TENDER CARE VETERINARY CENTER

1 of 8
SITE PLAN

Add PCD File No. PPR1839

Markup Summary

DRAWING INDEX

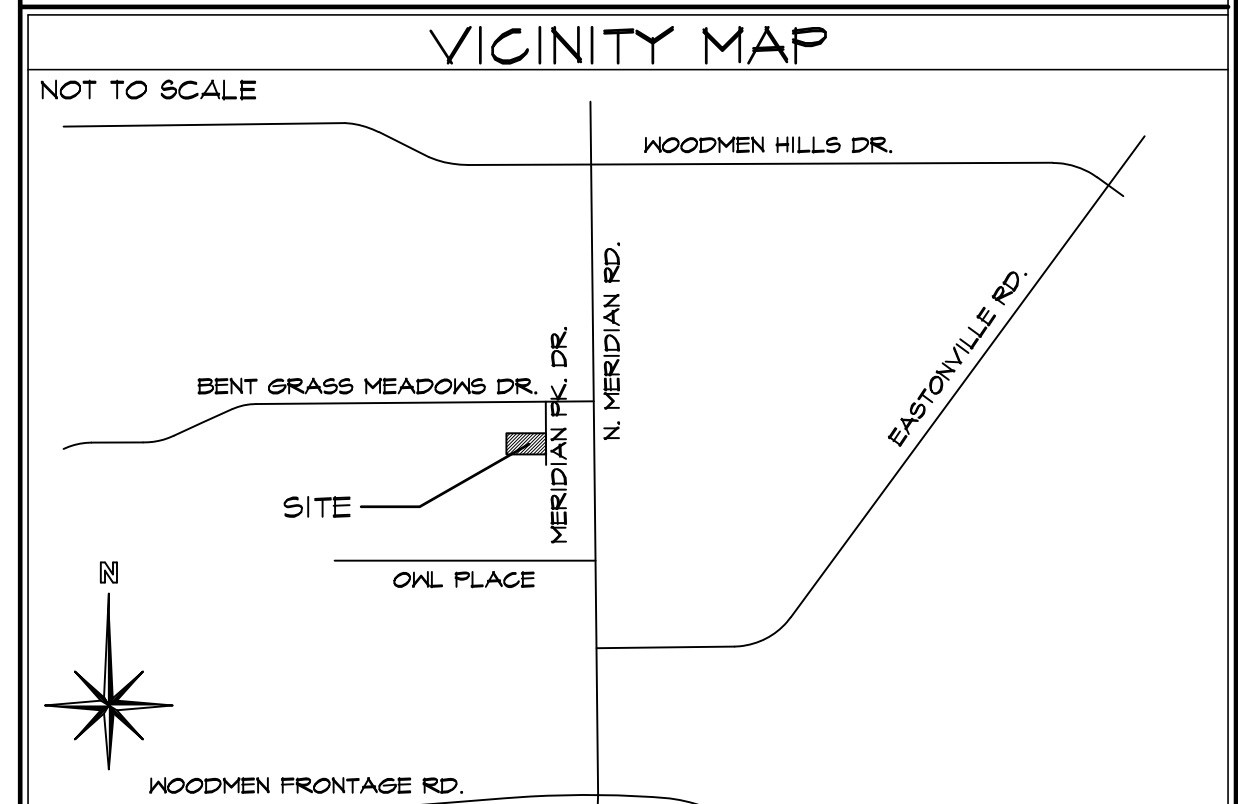
Contact El Paso County Public Works to determine if a work in ROW permit will be required for the second access and the sidewalk built within the ROW.

This parcel is a tract for the existing full spectrum detention pond.

Provide the rest of the sidewalk up to the property line.

An additional driveway access permit must be obtained for the proposed second access.

Show the curb opening as shown in the drainage report.

There are additional 20' drainage and utility easements on the plat which must be shown on the site plan.

Will there be curb and gutter here at the property line? If there is not curb and gutter proposed, then how do you plan on controlling the runoff through the parking lot from the north lot?

wrong #

why only here?

Please add the standard ADA route and note.

Please clarify the new and old area on the site development plan.

Not all platted easements have been shown.
Please add.
